**Subject: Independent Fire Protection Review for Cumberland County Civic Center Renovations**

A review has been completed of the fire protection construction documents (CD) set, dated 21 January, 2013, which has been developed to support renovation efforts at the Cumberland County Civic Center in Portland, ME. The documents reviewed included both the fire protection demolition and design drawings, along with the design specifications for the various fire protection and life safety related systems.

2 PART PLAN - FIRE PUMP ROOM
1/4" = 1'-0"

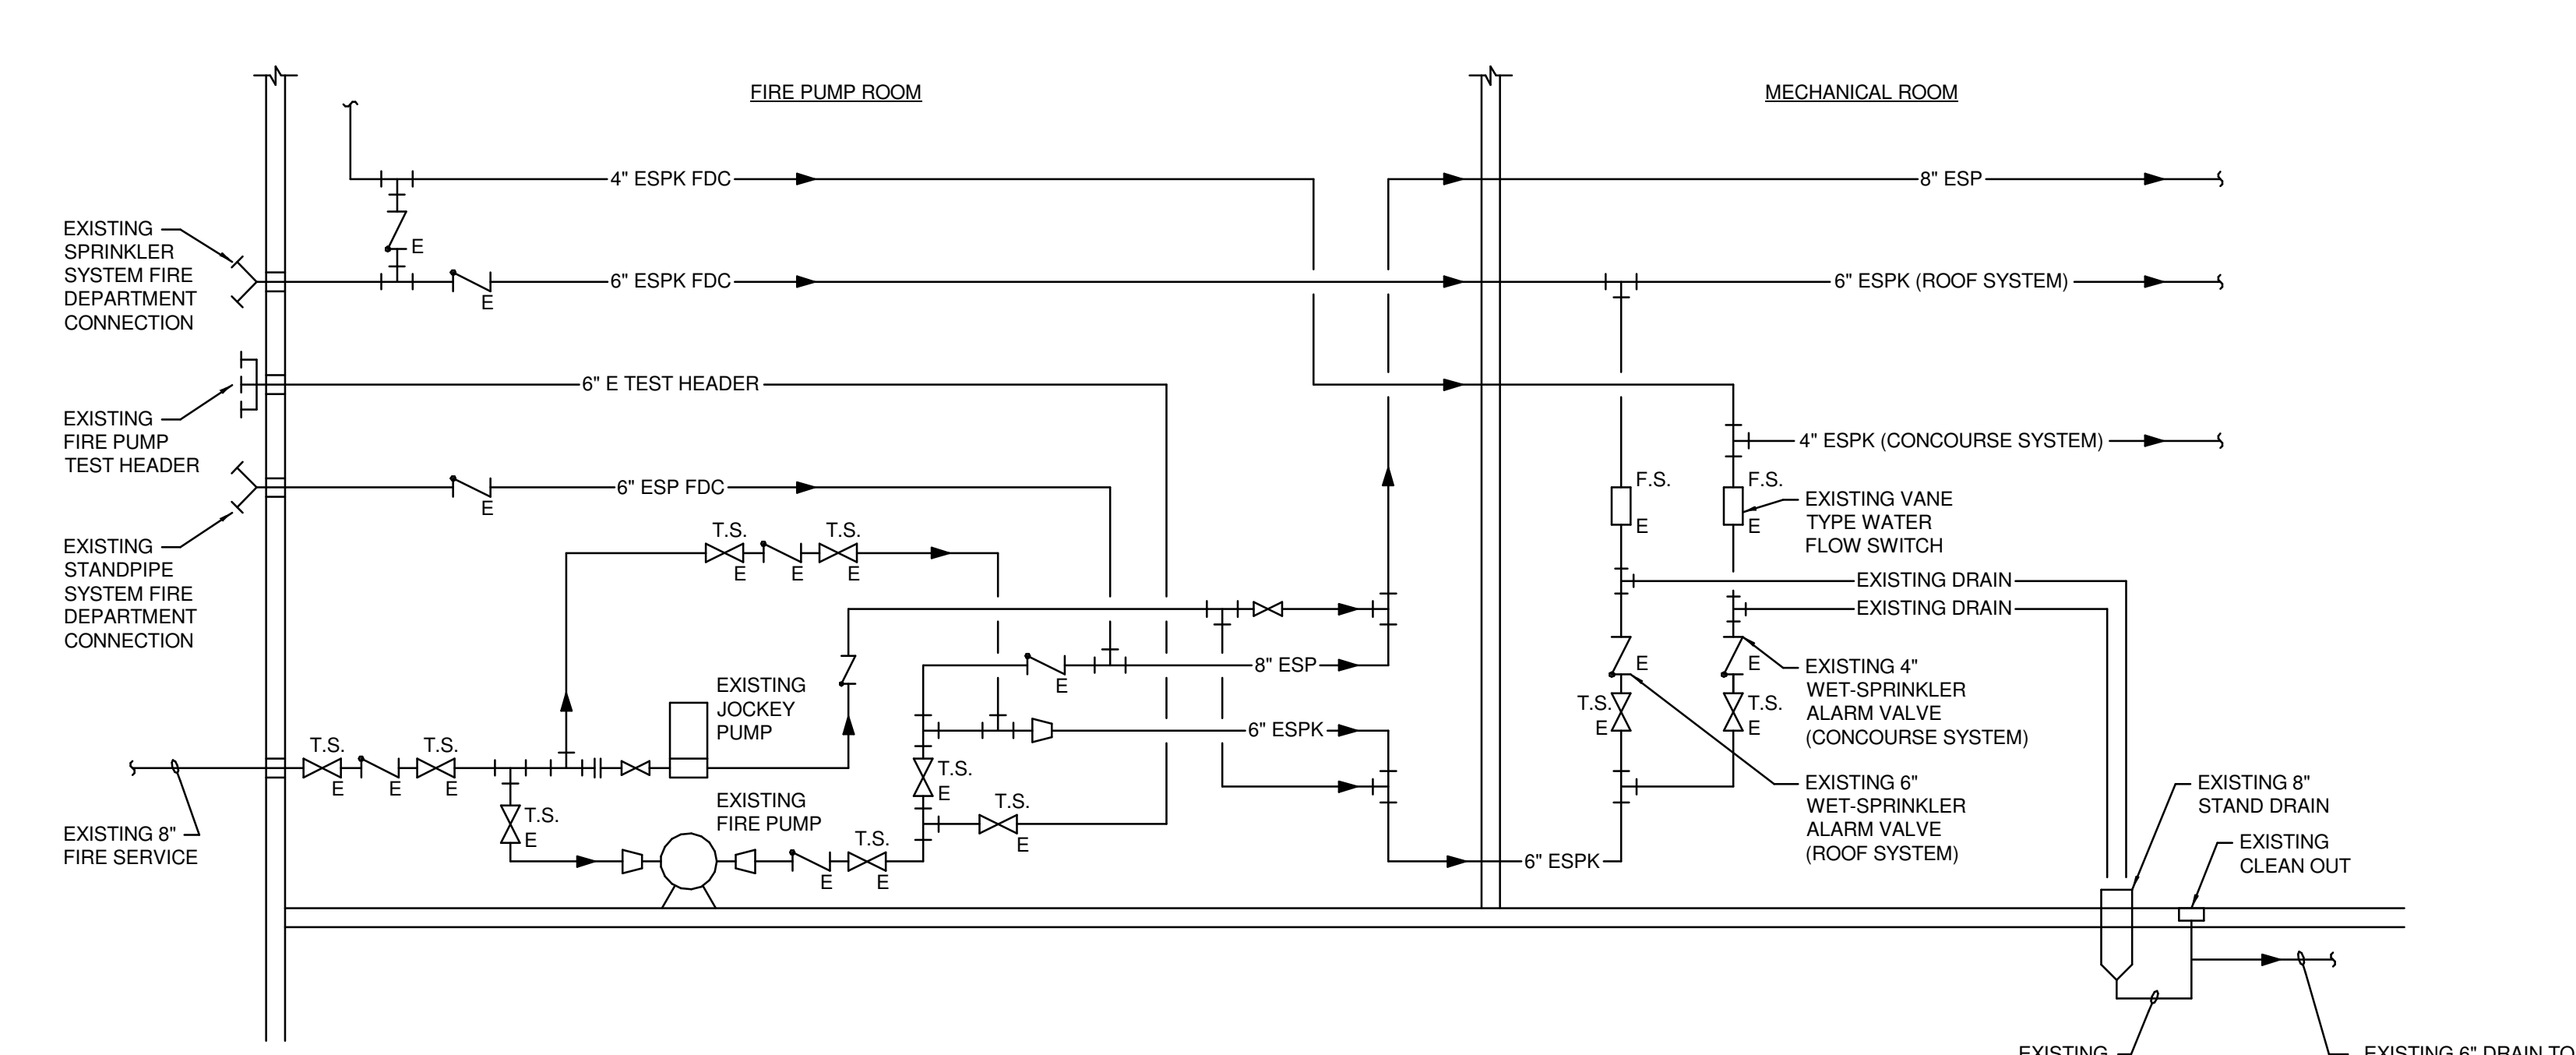
Item 1.4.B should be expanded and clarified. A fire pump does exist for this facility; yet no mention is made of this and how it may, or may not, support the sprinkler systems. This is likely to be a point of confusion for any contractor that may be charged with design/installing these systems. The drawings indicate that the fire pump does supply the sprinkler systems. The specific flow characteristics for the fire pump (pump rating) should be provided, such that it can be used to support the necessary hydraulic calculations.
